MEMORANDUM

RE: Traffic Memorandum for Space Village Apartments
 El Paso County, Colorado

Add PCD File No. VA201

VICINITY MAP

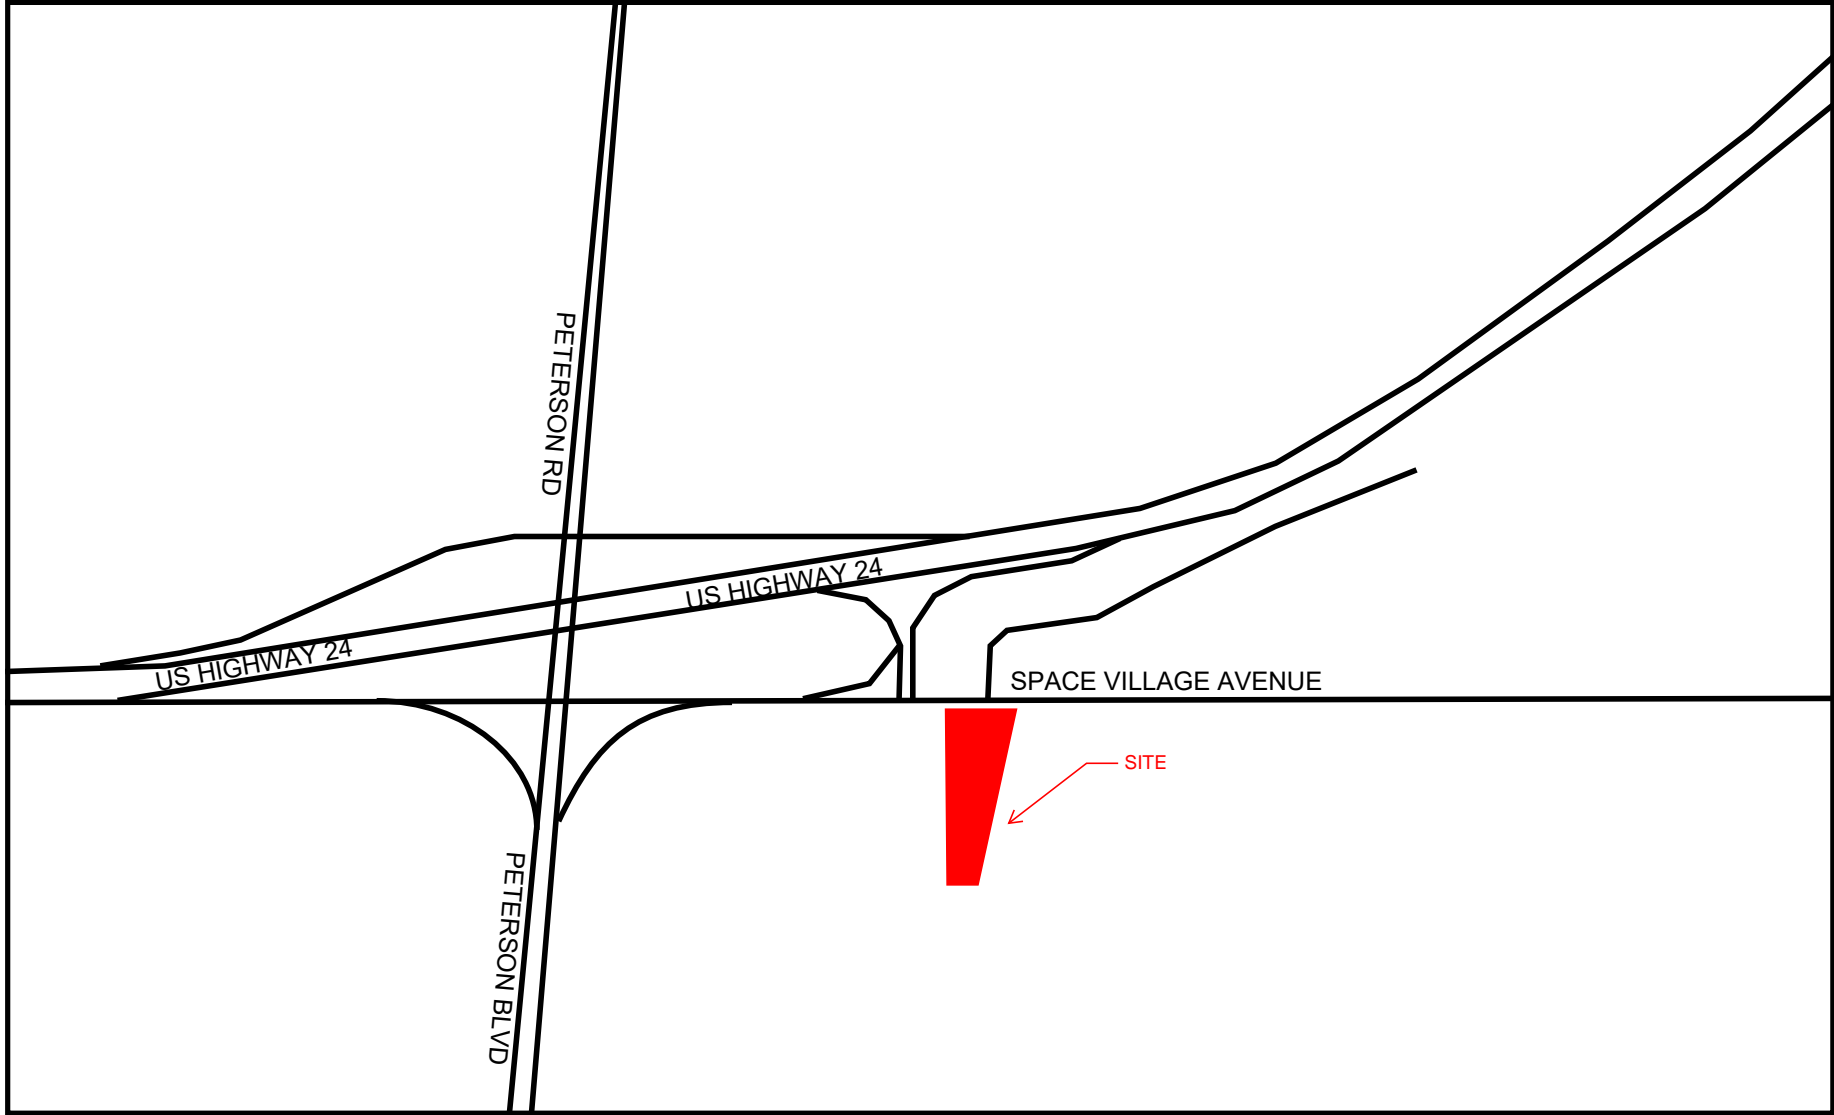
- Please provide the following traffic report standards (ECM Appendix B.8)
- Clearly state in the text and supporting documents what the ADT and peak hour traffic are at all access currently,
 - State whether or not any Improvements affected by the project are reimbursable under the current MTCP
 - State whether the MTCP or other approved corridor study calls for the construction of improvements in the immediate area
 - Include discussion of the road impact fee
 - Include LOS for all affected intersections
 - If an intersection does not meet LOS D or better discuss what steps can be taken to bring the intersection to a satisfactory level
